Re: Hsiao Short Plat – *Technical Review 1*  
SP22-004

RE: Hsiao Short Plat, File# SP22-004  
Preliminary Short Subdivision of 1.14 acres into five (5) single-family detached lots  
4100 81<sup>st</sup> Place NE & Parcel # 00550600001200, 00550600001300, 30052100314700

ACCESS ROAD CENTERLINE PROFILE

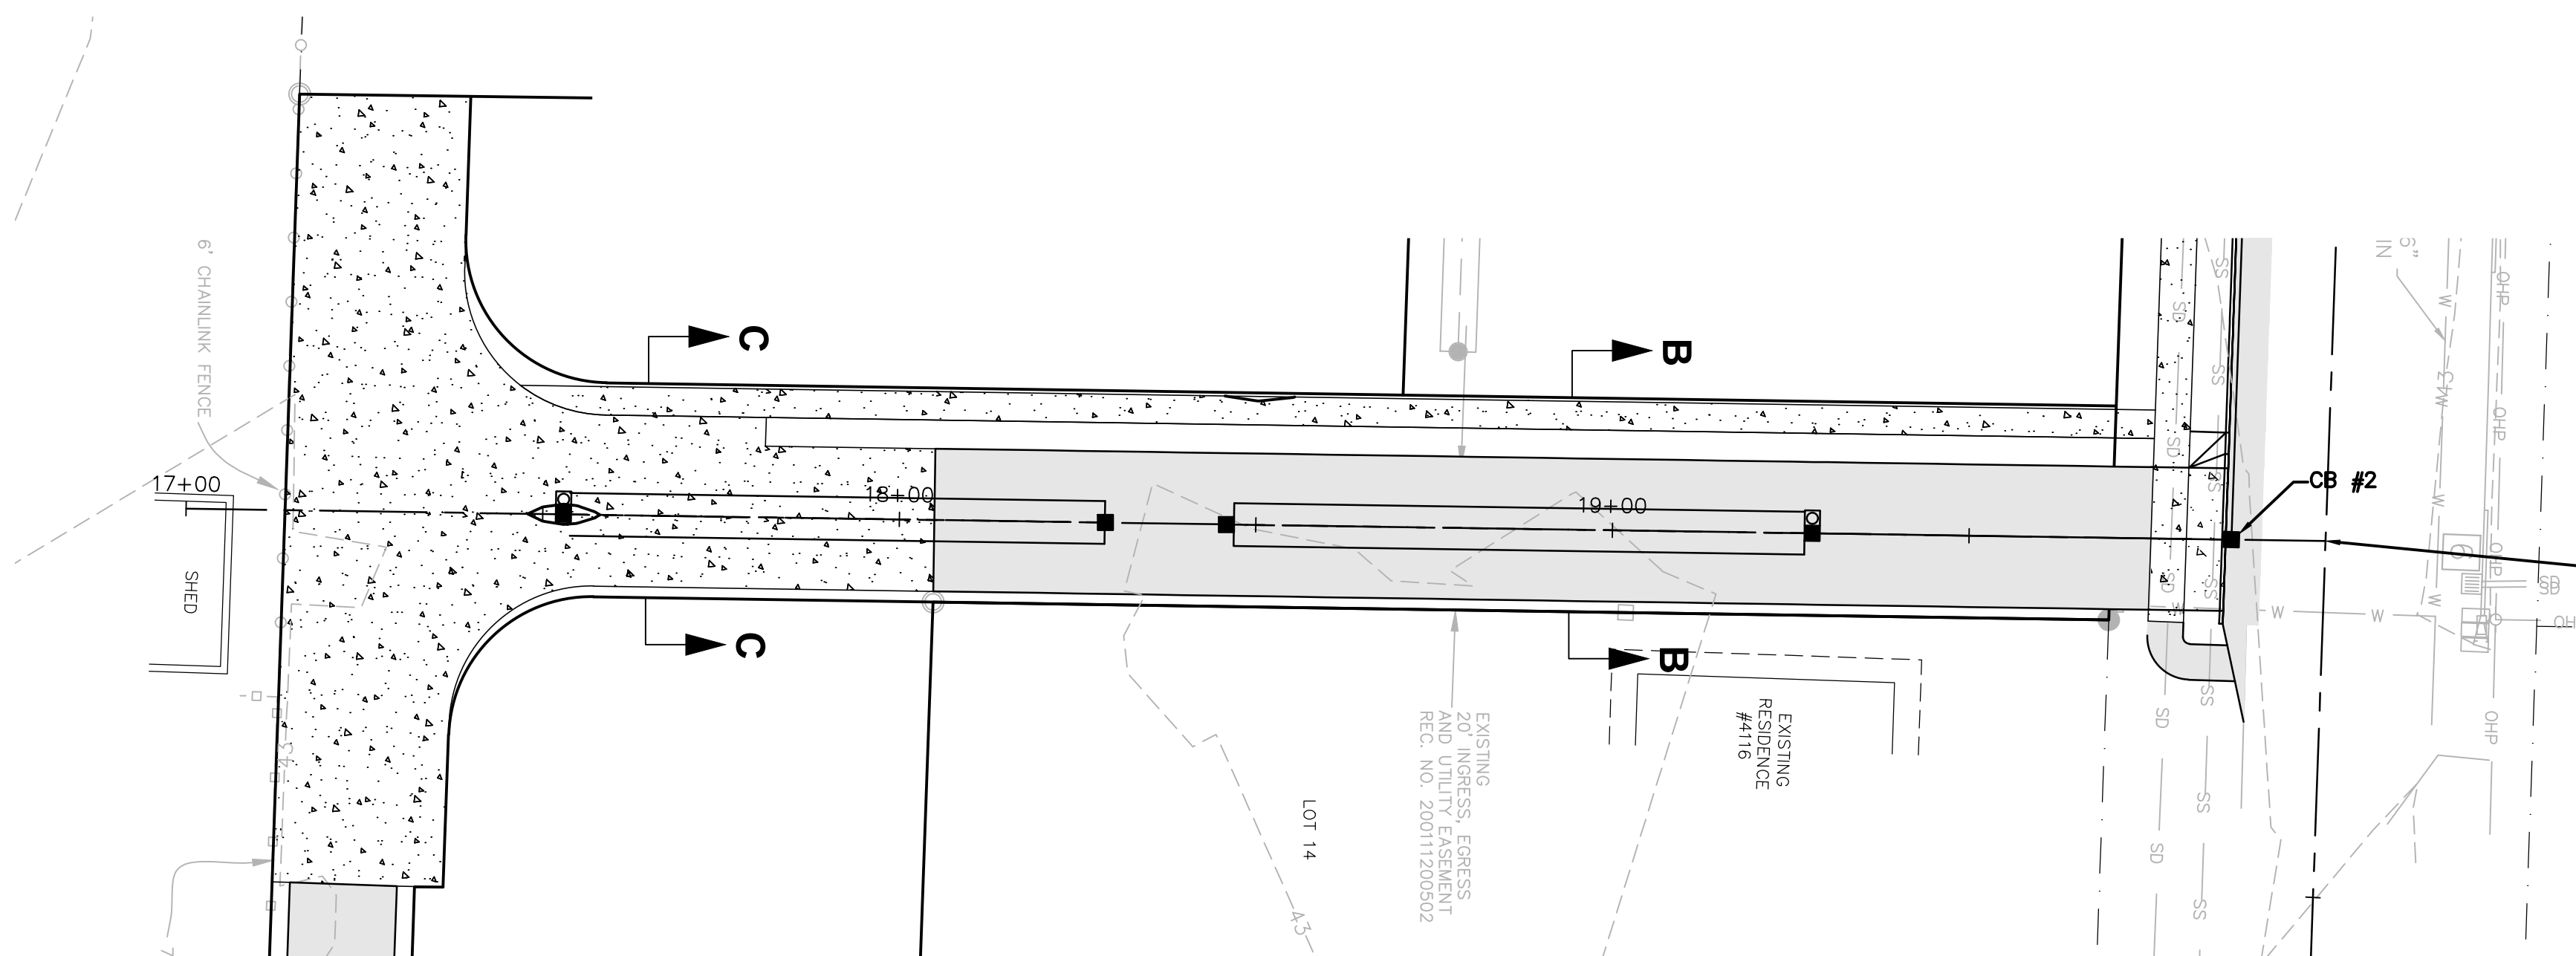
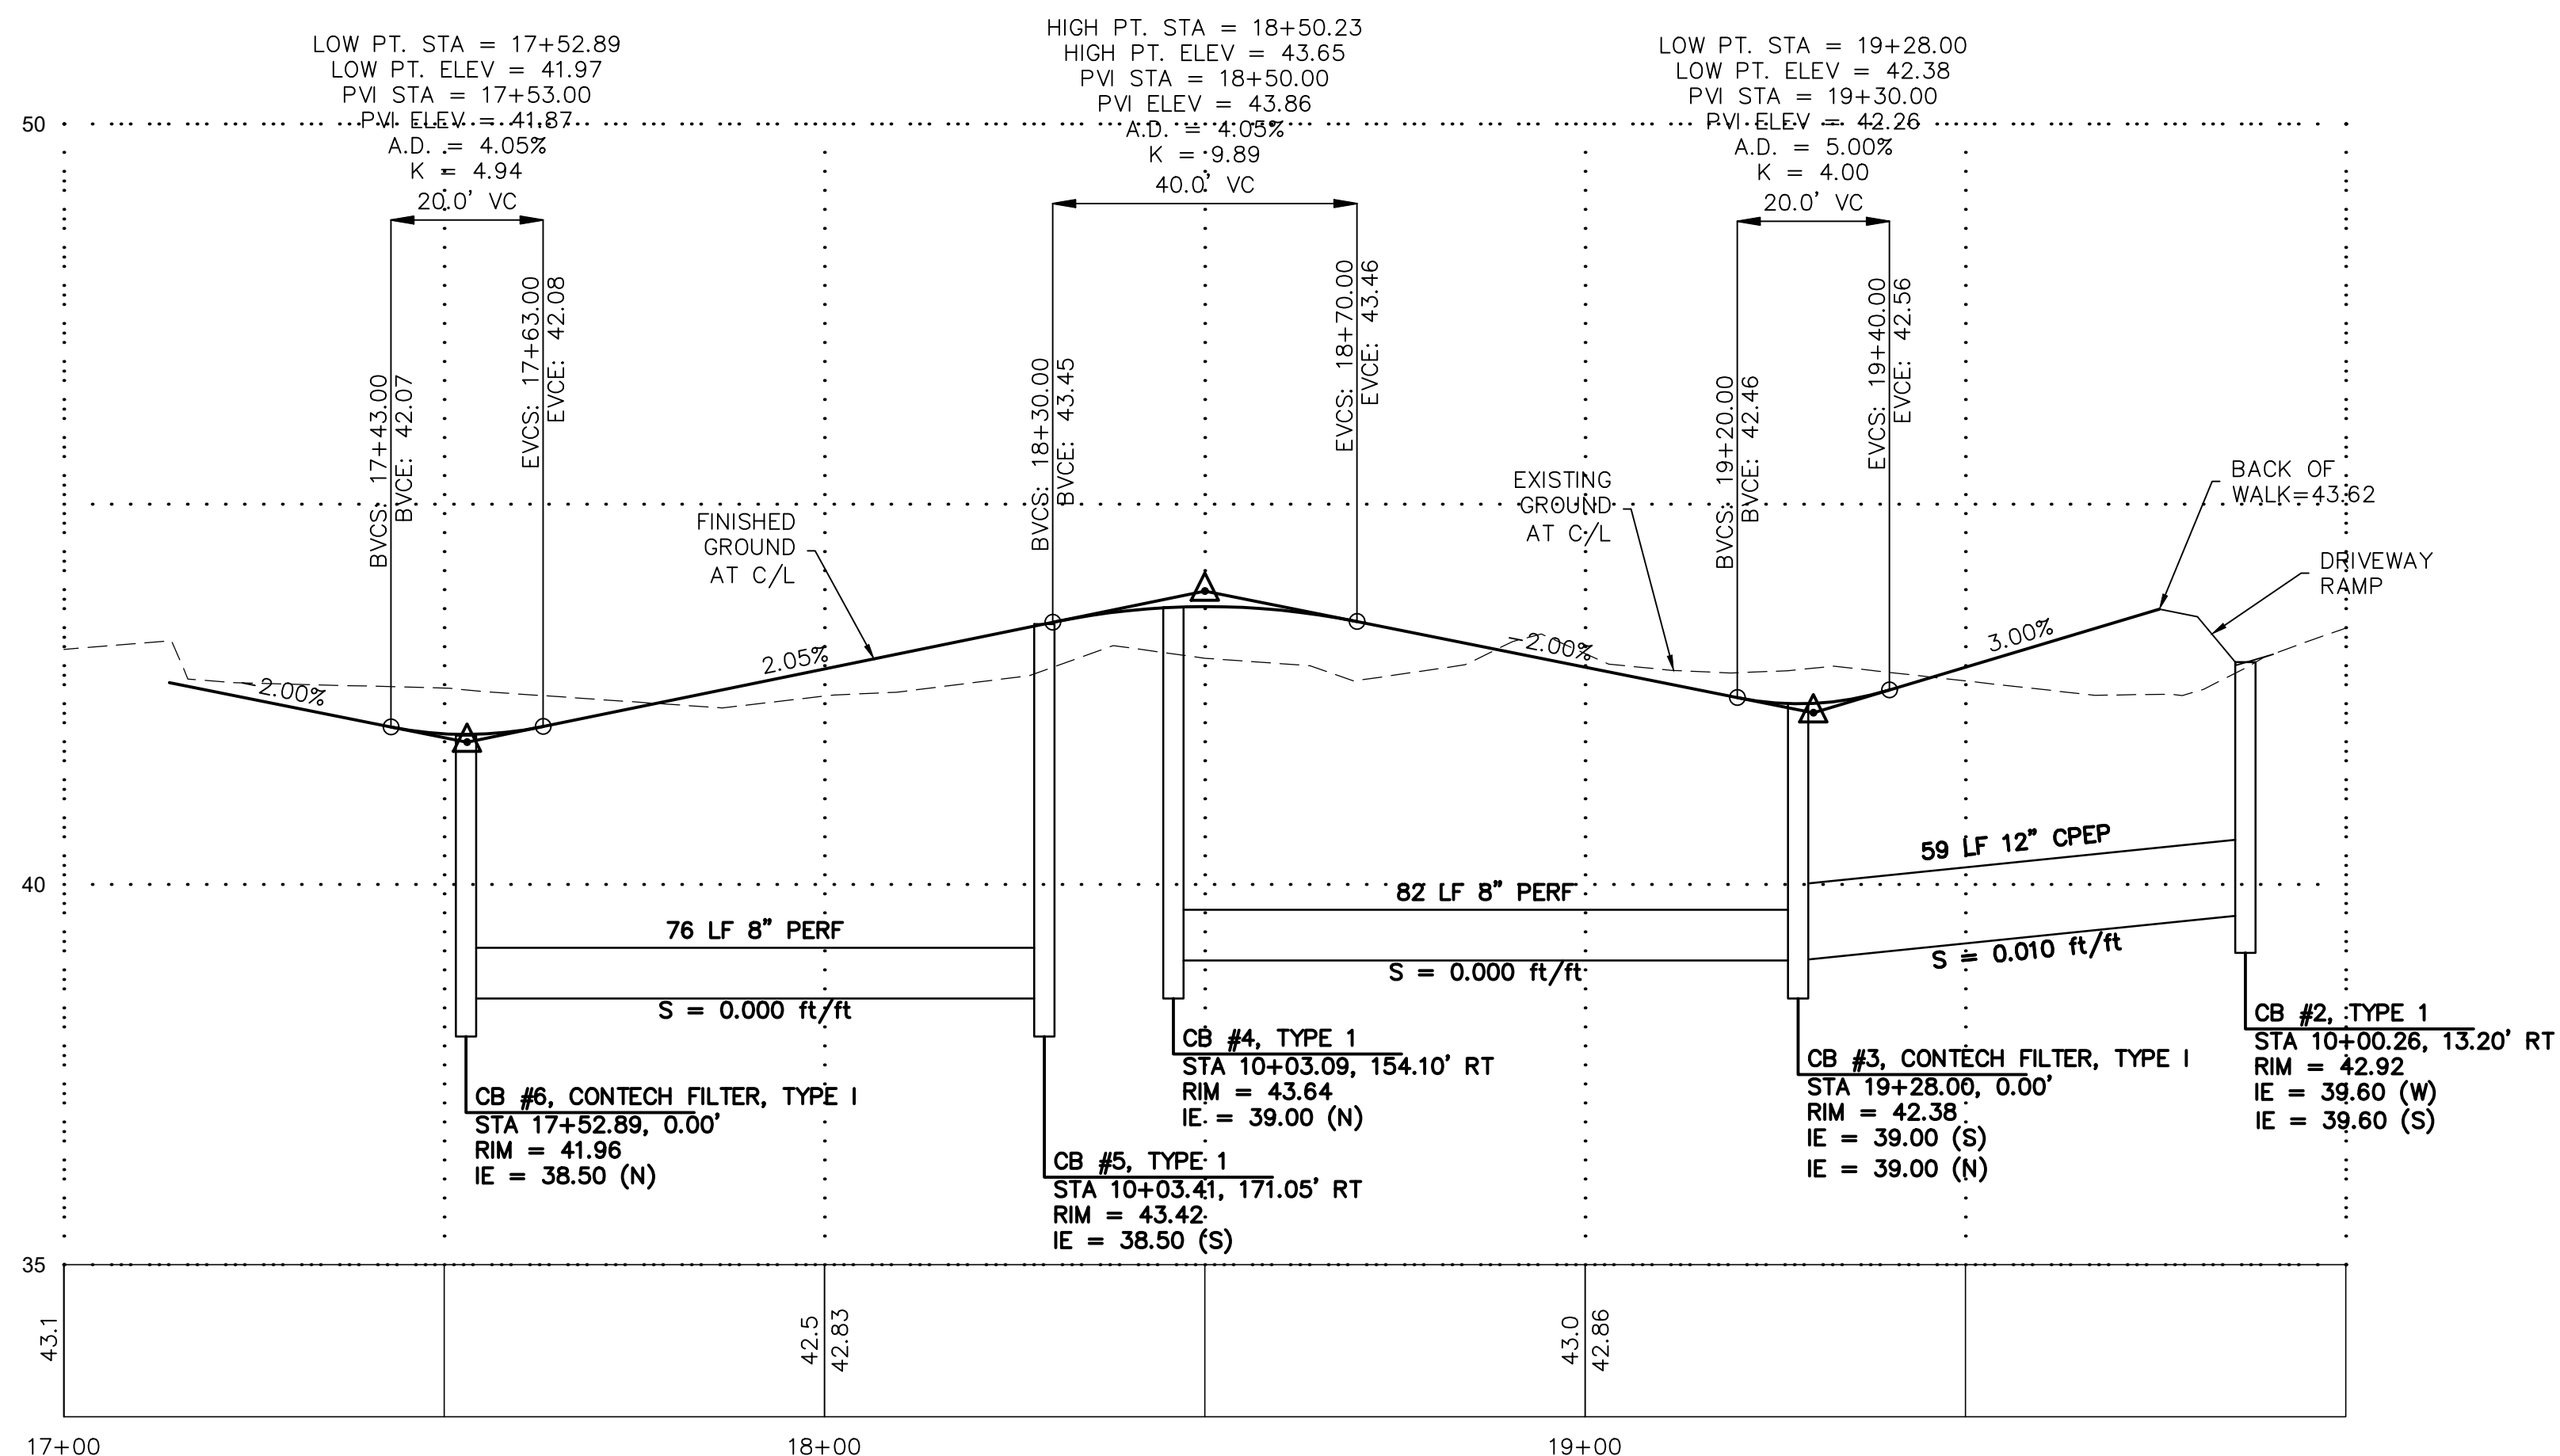
4. The portion of the hammerhead turnaround and accesses to Lots 4 & 5, beginning at the northern property boundary of Lot 4, shall be constructed with scored concrete, paving blocks, bricks, or other ornamental pavers to clearly indicate that the entire surface is intended for pedestrians as well as vehicles. Update the Preliminary Civil Plans accordingly. This will be a condition of preliminary SP Approval

5. Provide a detail on the civil construction plans demonstrating adequate on-site turnaround on Lot 5, ensuring residents are not required to back out onto the Access Tract. This will also be required to be demonstrated, prior to building permit issuance, and shall be a condition of preliminary SP approval.

SEWER & WATER PLAN

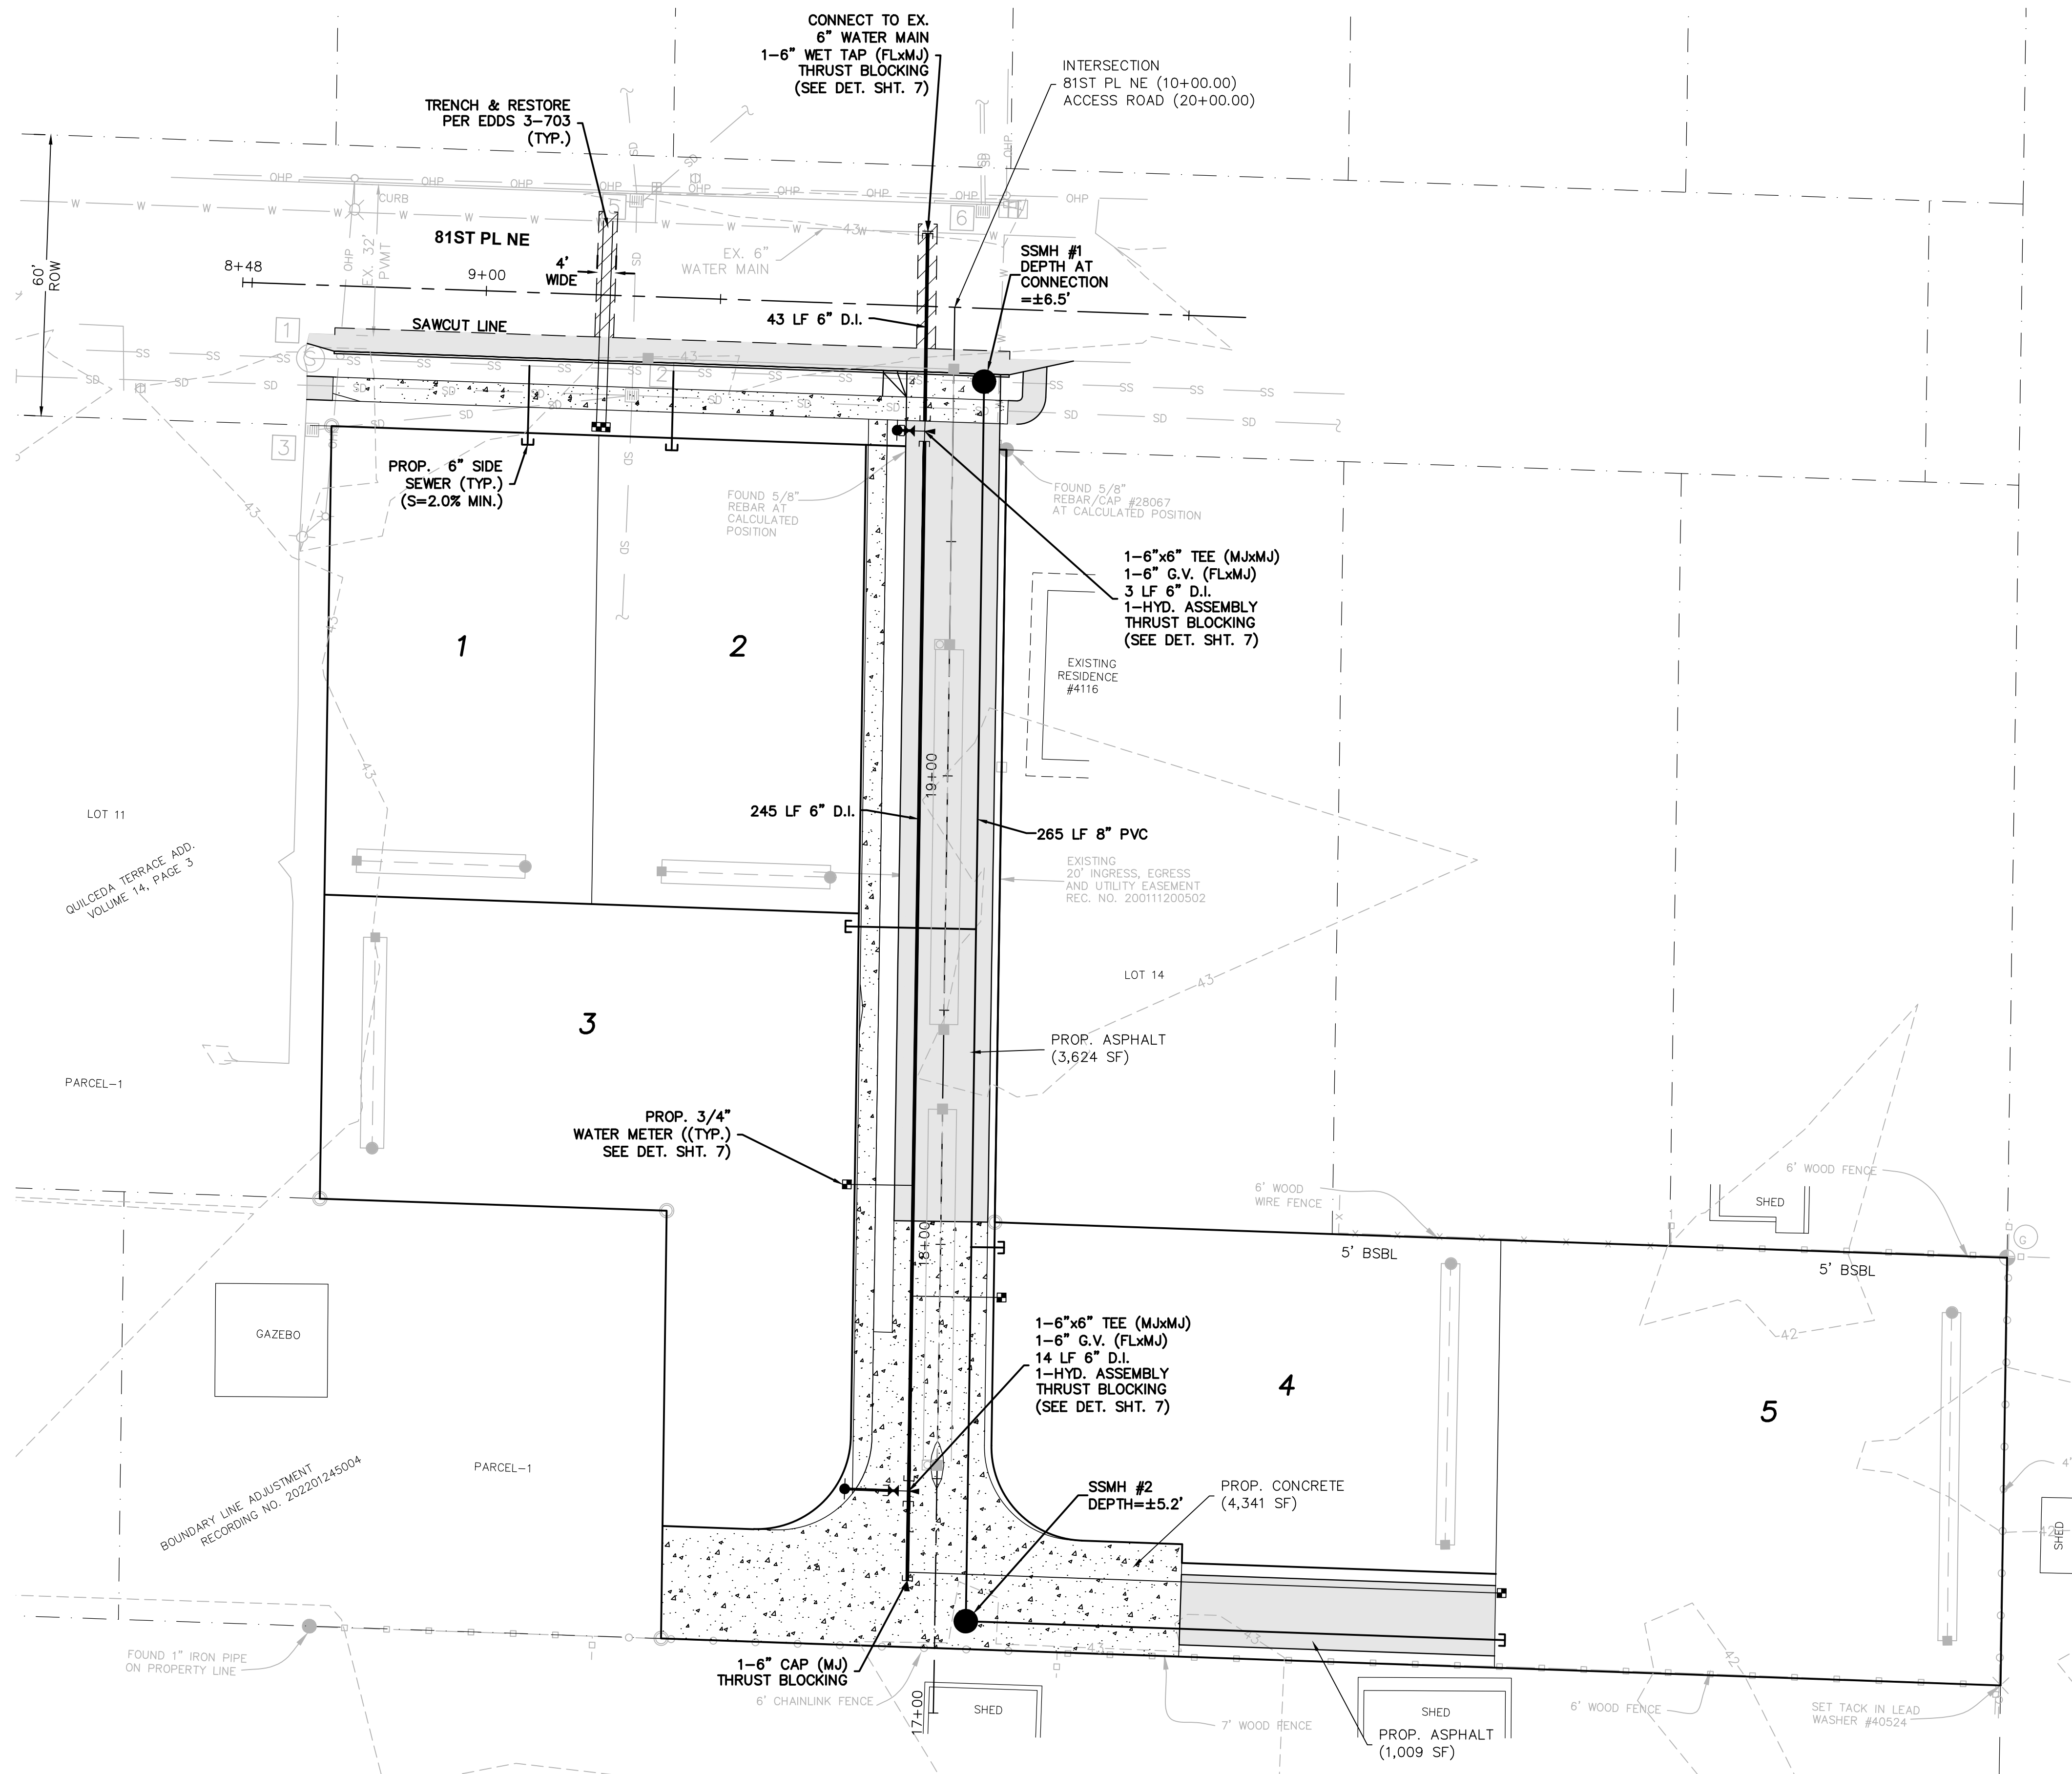
- a. Sanitary sewer: Please end the sewer run with a manhole instead of a lamphole and stub the side sewer for Lot 5 out of the manhole.
- b. Water: Please include water details such as pipe size and material. The water main will need to be extended to the end of the private street with the service to lot 5 coming off the main at a 90 degree angle and run perpendicular to the main directly to the lot. The end of the run will need a hydrant or a blow off installed.

1. Water details not shown;
2. Size, material and length of new water main not shown;
3. End of water main will require at a minimum a blow off assembly;
4. Water service line for lot 5 appears to exceed the maximum service line length of 110';
5. Service lines are preferred to be installed perpendicular to water main.
